Ribble Valley Borough Council
By email

Your ref 3/2025/0870
Our ref DC/25/2866v2
Date 05-JUN-26

Location: 18 Accrington Road (Former Whalley Motor Services) Whalley BB7 9TD.
Proposal: Proposed demolition of former motor services building and construction of new office building.

7261 -003D

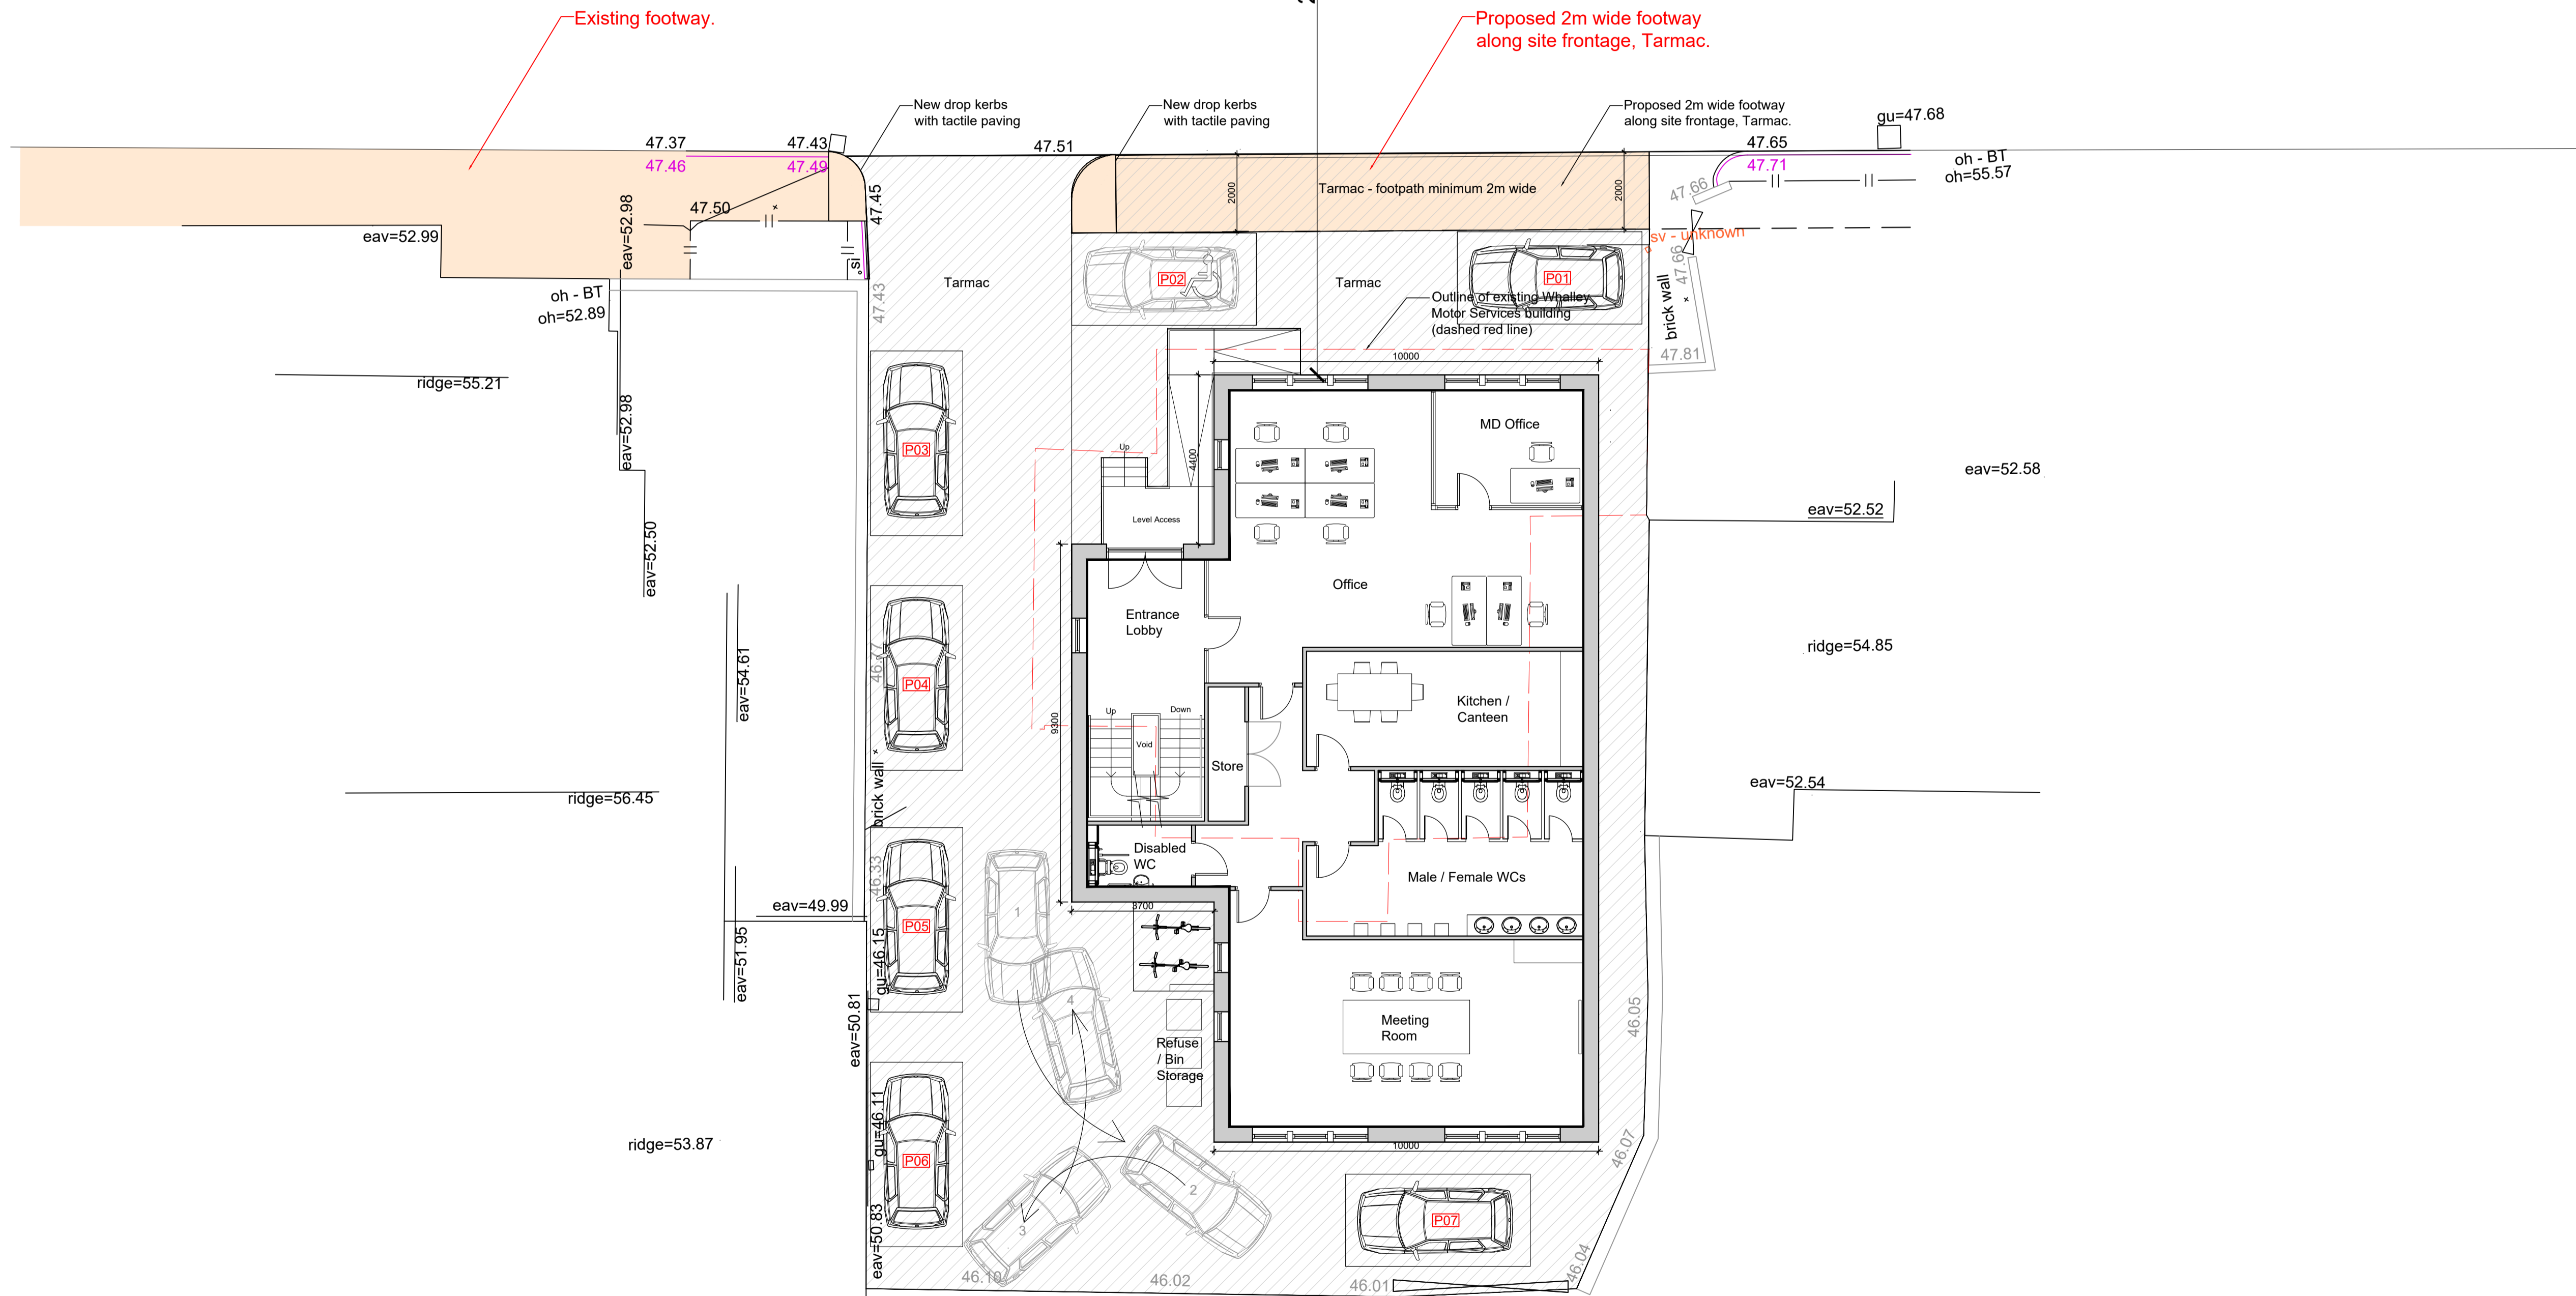
A public sewer crosses the site and we will not permit building over it. We require an access strip for maintenance or replacement and this access must not be compromised in any way. The minimum distances that might be acceptable to United Utilities are detailed within Part H of the Building Regulations however, we recommend the applicant determines the precise location, size, depth and condition of the pipeline as this is likely to influence the required stand-off distance from any structure.

Based on the information currently available, it is unclear whether sufficient distance is provided between proposed development features and our wastewater asset(s). We recommend the applicant contacts our Developer Services team to ensure existing wastewater assets, along with our required access widths, can be accommodated in the proposed layout. If the applicant fails to investigate and resolve any concerns prior to a positive determination, there is a risk that as the scheme progresses, the applicant, or any subsequent developer, may discover that their plans are not implementable in their existing form or that diversion of assets is required. If the Local Authority requires any additional comment on the acceptability of the proposed layout from United Utilities, we will require a detailed site layout plan, which overlays the PROVEN location of the wastewater asset(s) in relation to any proposed development (including walls, fencing, parking etc.). In this scenario, we will require evidence to show that the location of the pipeline(s) has been confirmed by site specific survey, a copy of asset maps will not suffice.
